memorandum

SUBJECT: LOT: 25 DP: 2954; LOT:24 DP: 1152887, NO. 97-151 WALLGROVE ROAD, HORSLEY PARK (WALLGROVE ROAD BUSINESS PARK)

FILE: SSD-50972718

DATE: 16 April 2024

2 SECTION BB - STAGE 1 STREET FRONTAGE SCALE 1:50

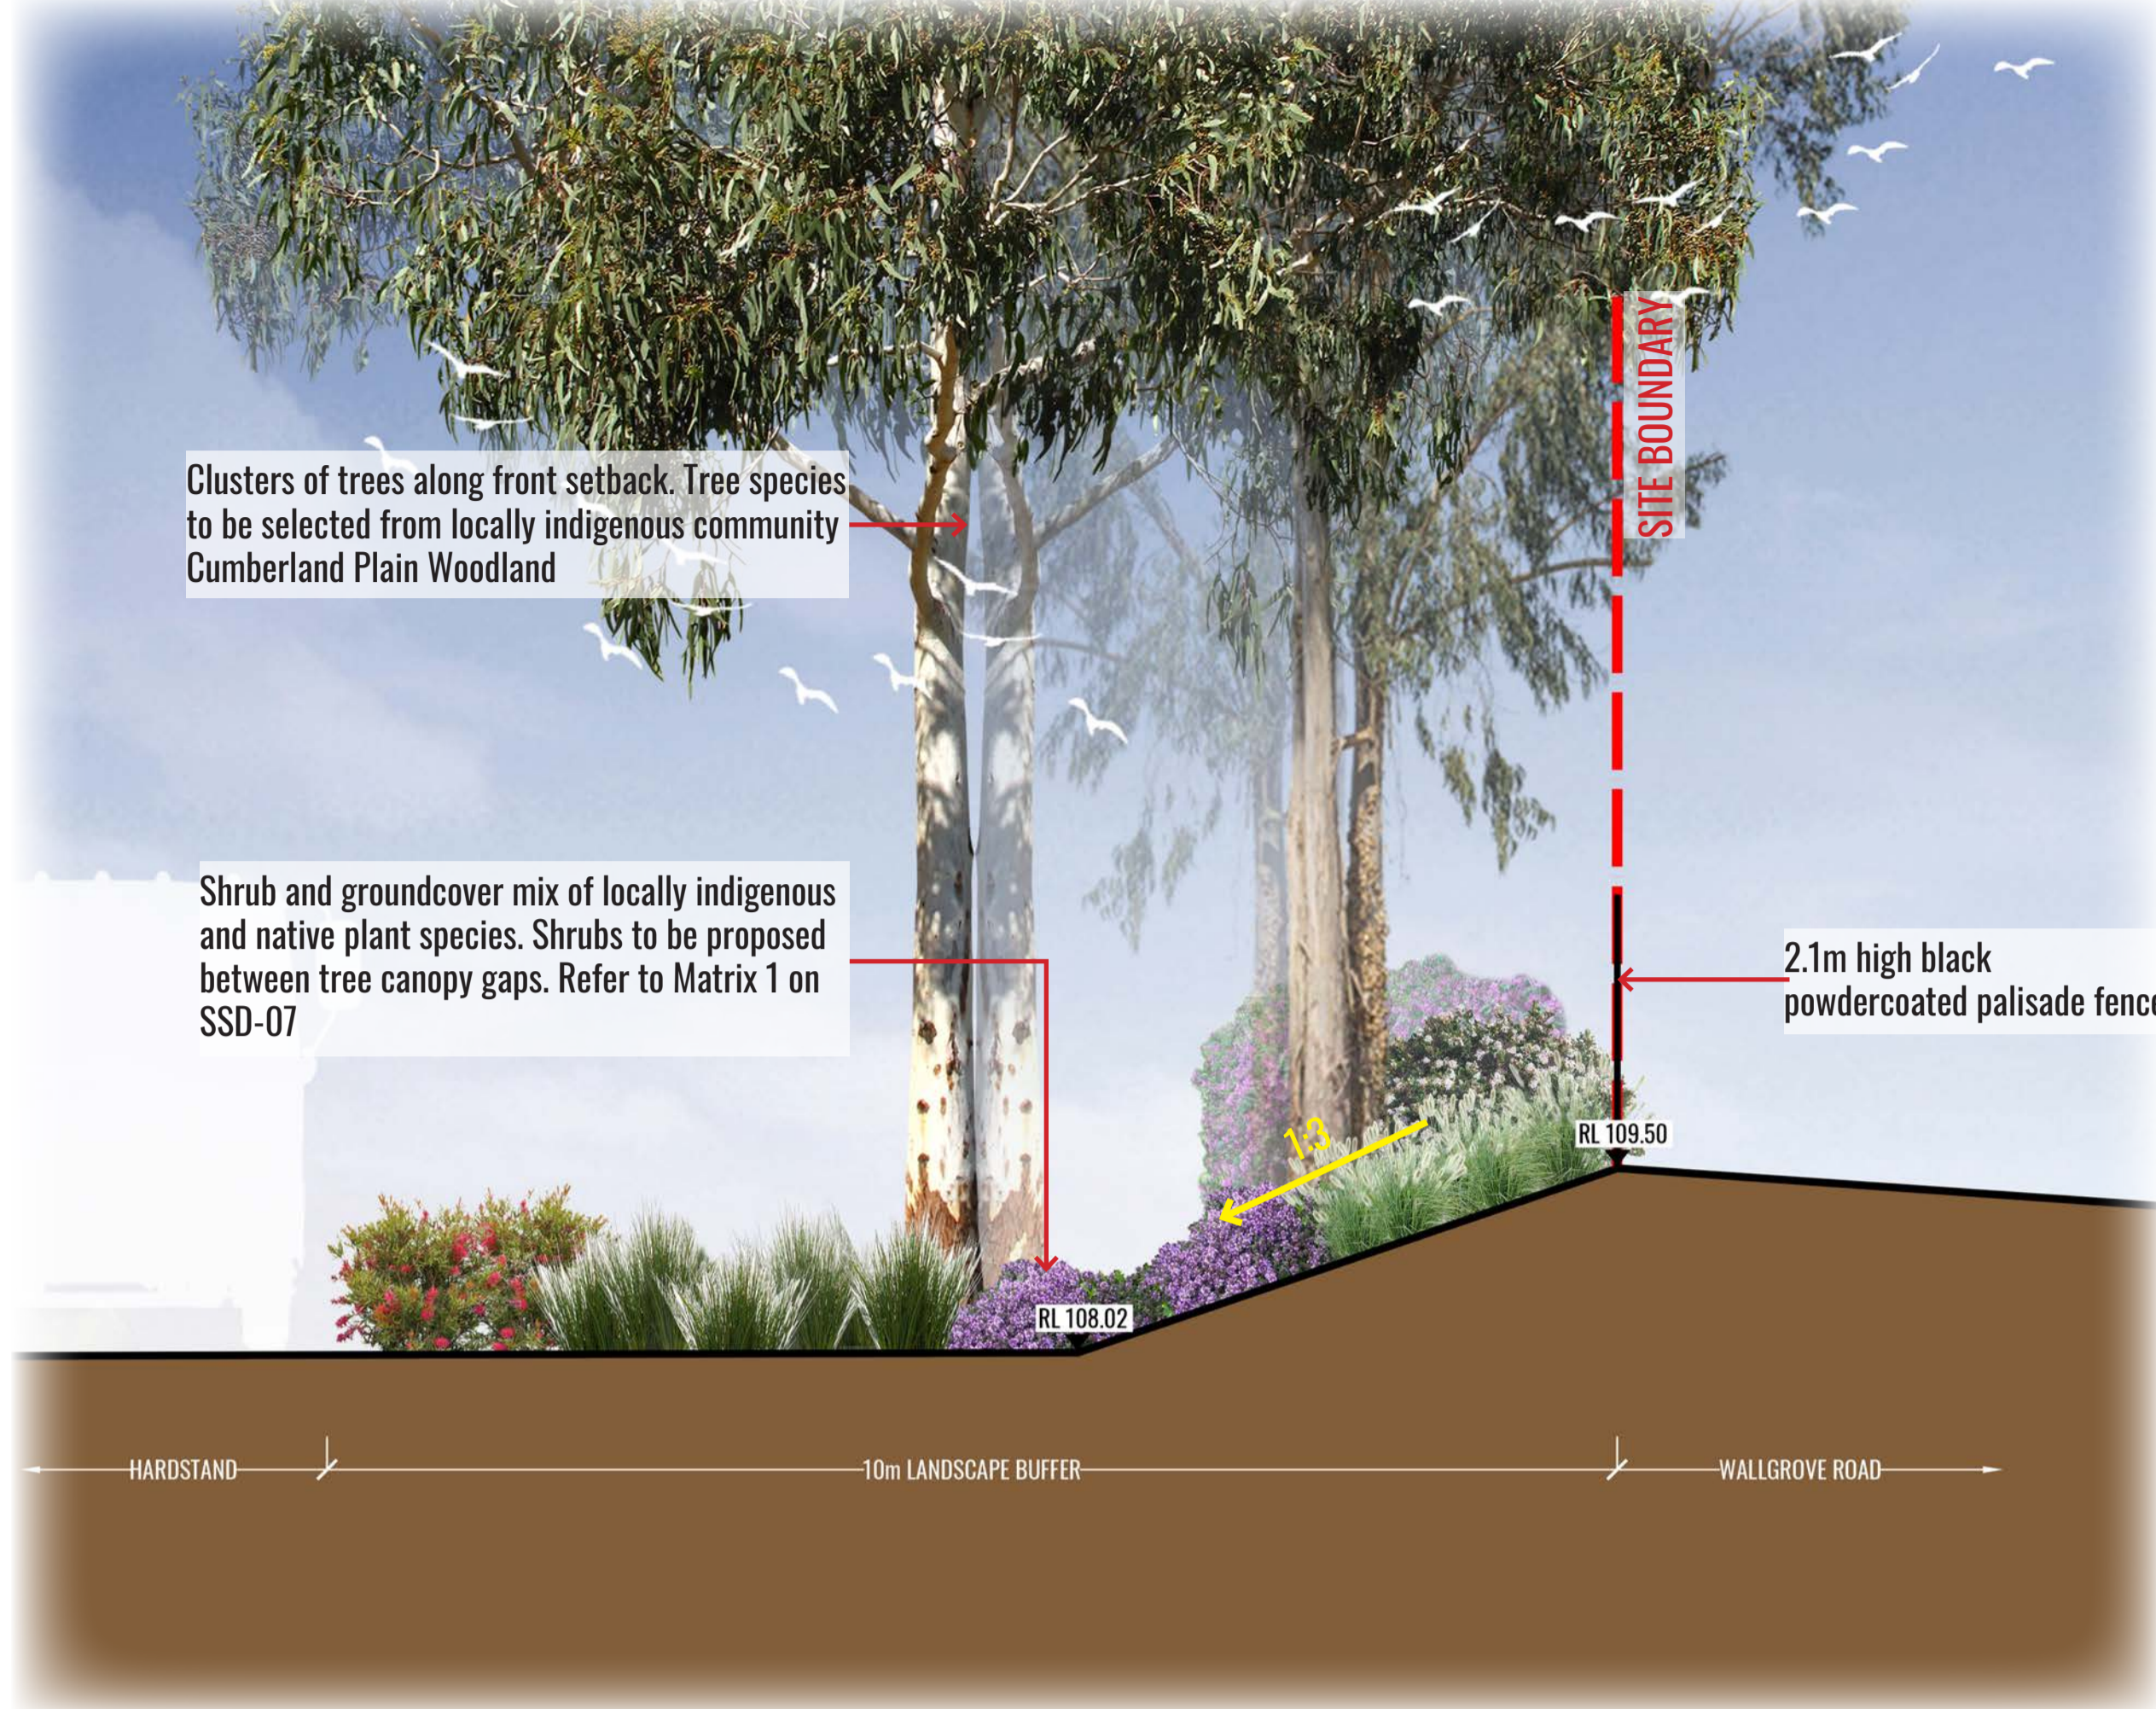
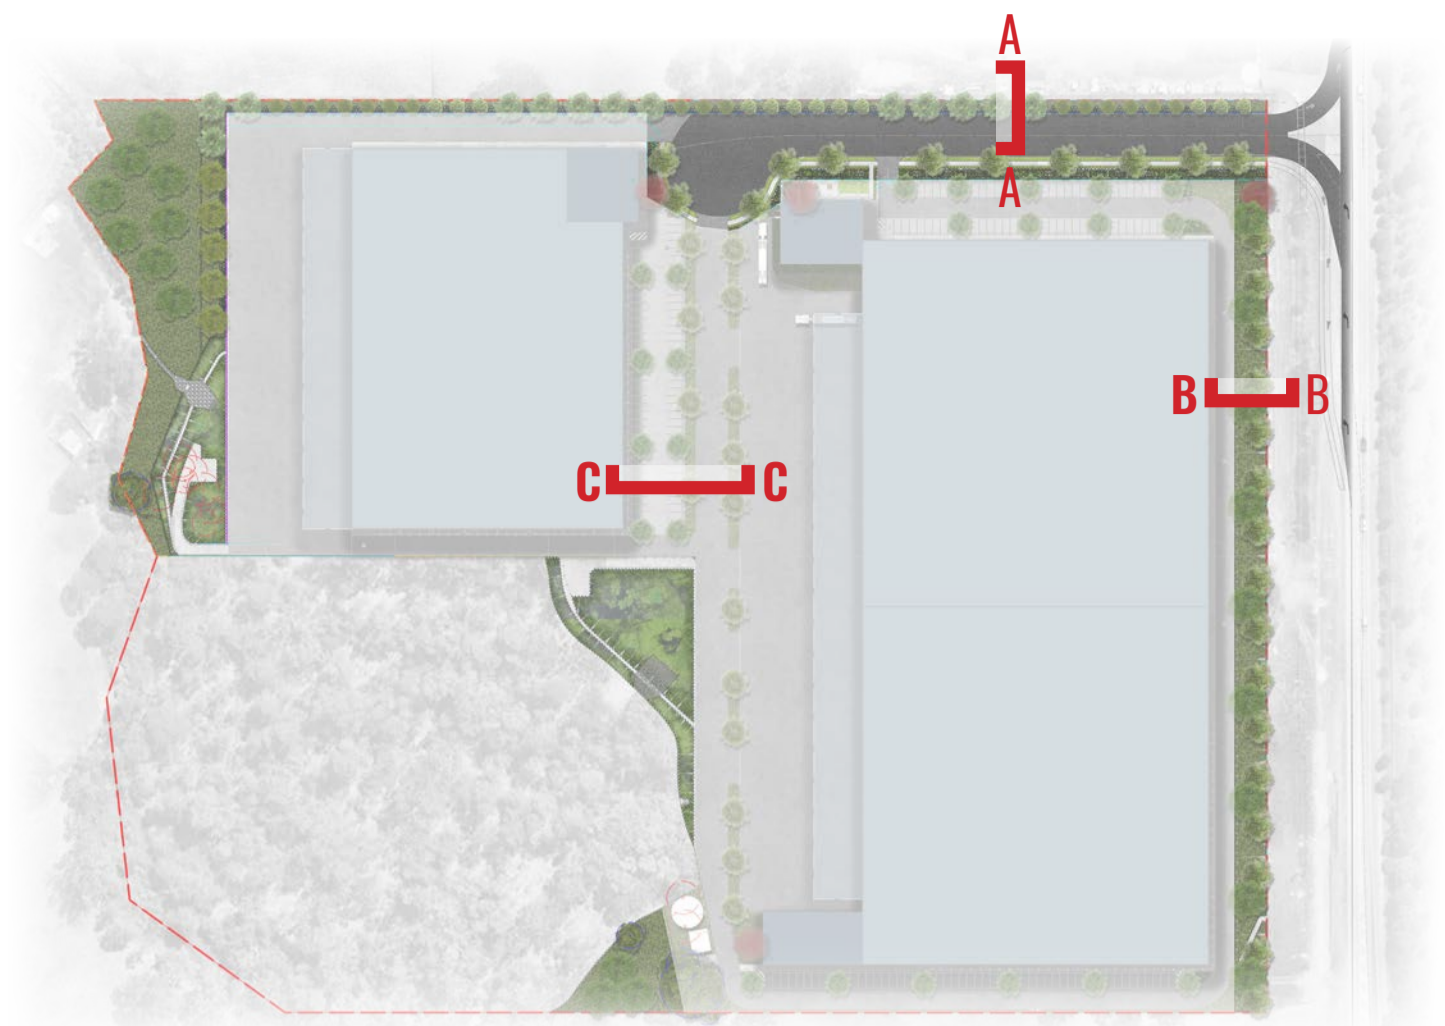
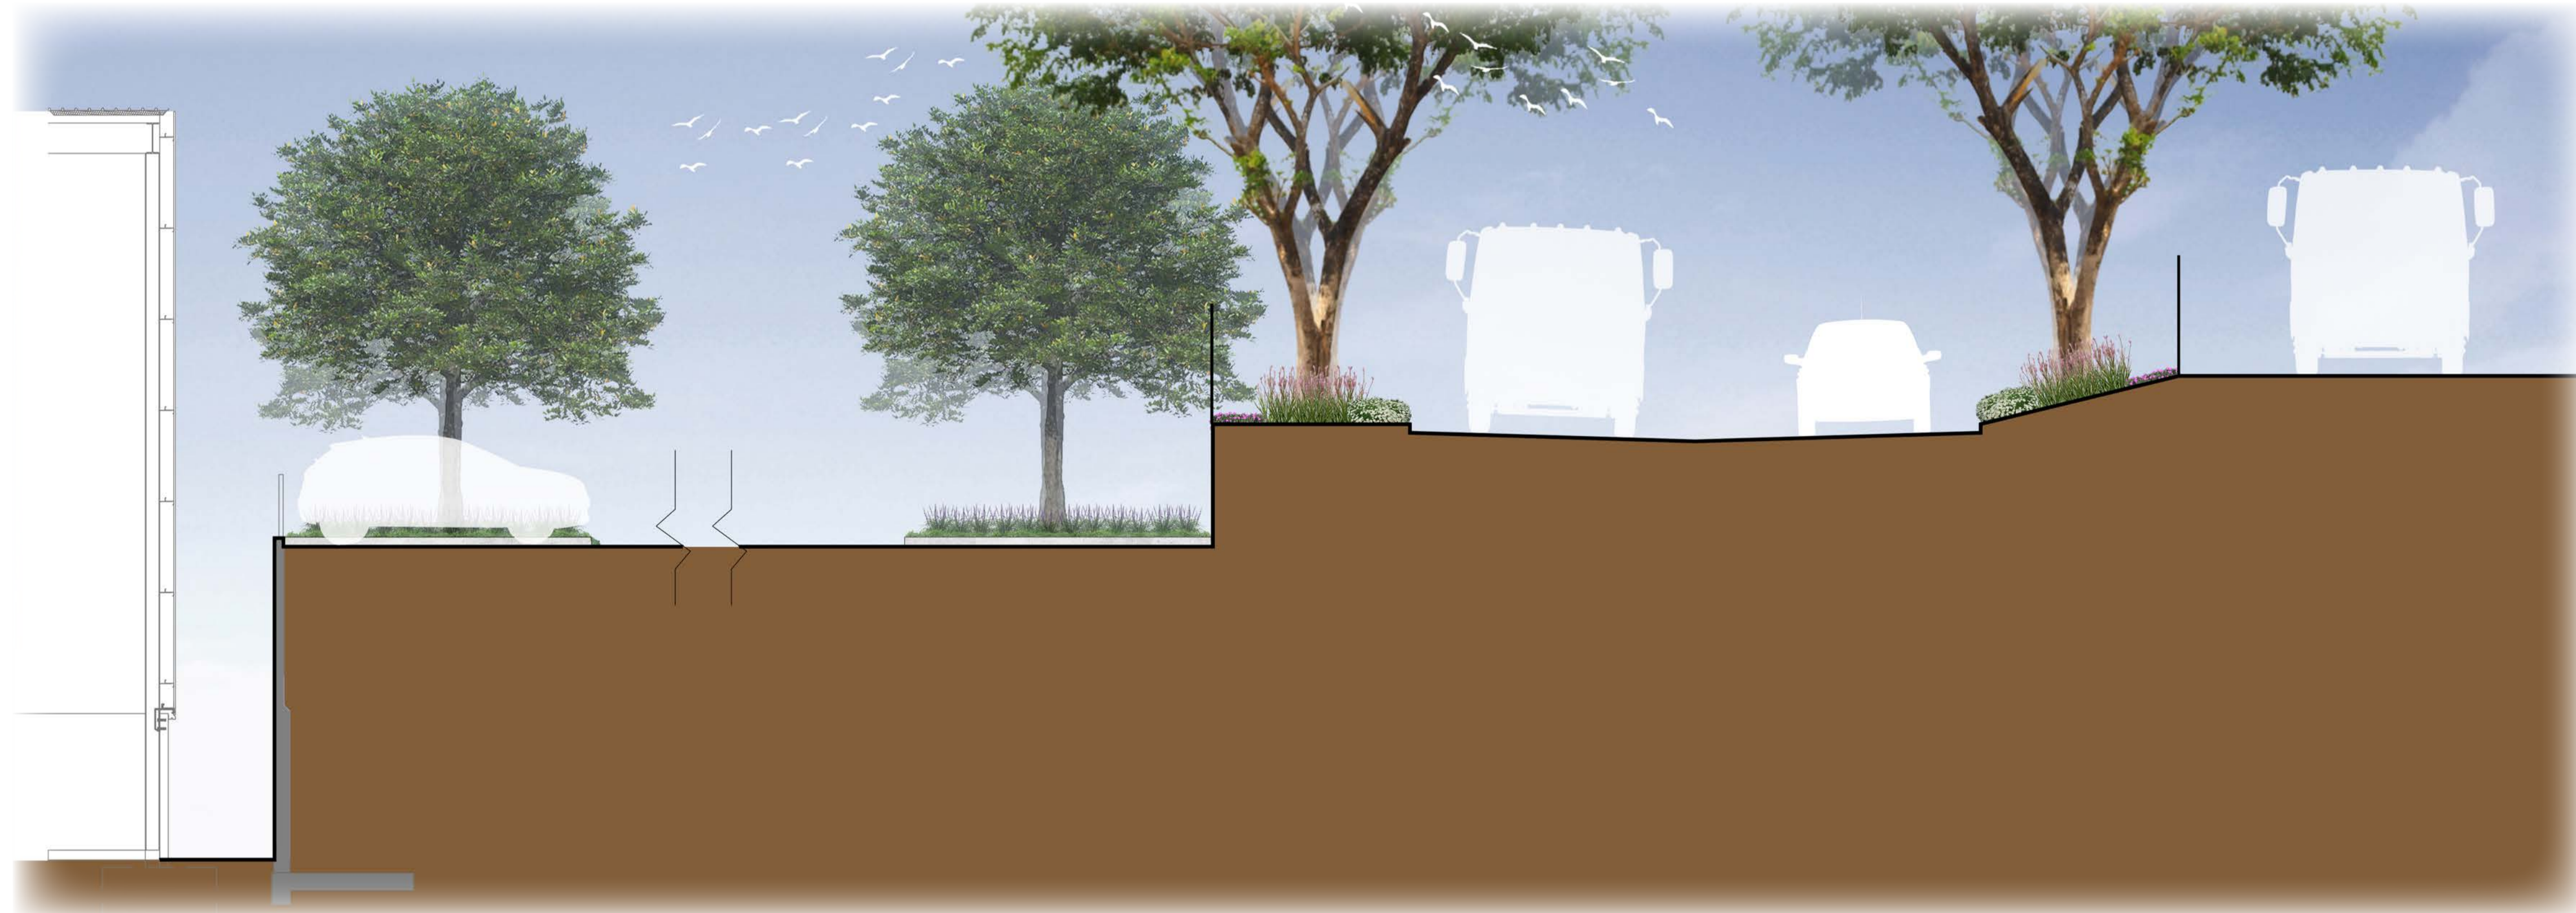
- Proposed the retaining wall in the road reserve which will be Council burden assets, creating more maintenance issues and liability to Council, refer typical sections. We recommend that it should be located within the proposed lots.

- In the detail plan, consideration is given to have sub-soil drainage system on both sides as required to prevent the ingress sub-surface run-off to the road pavement. Refer as marked in red on the drawing
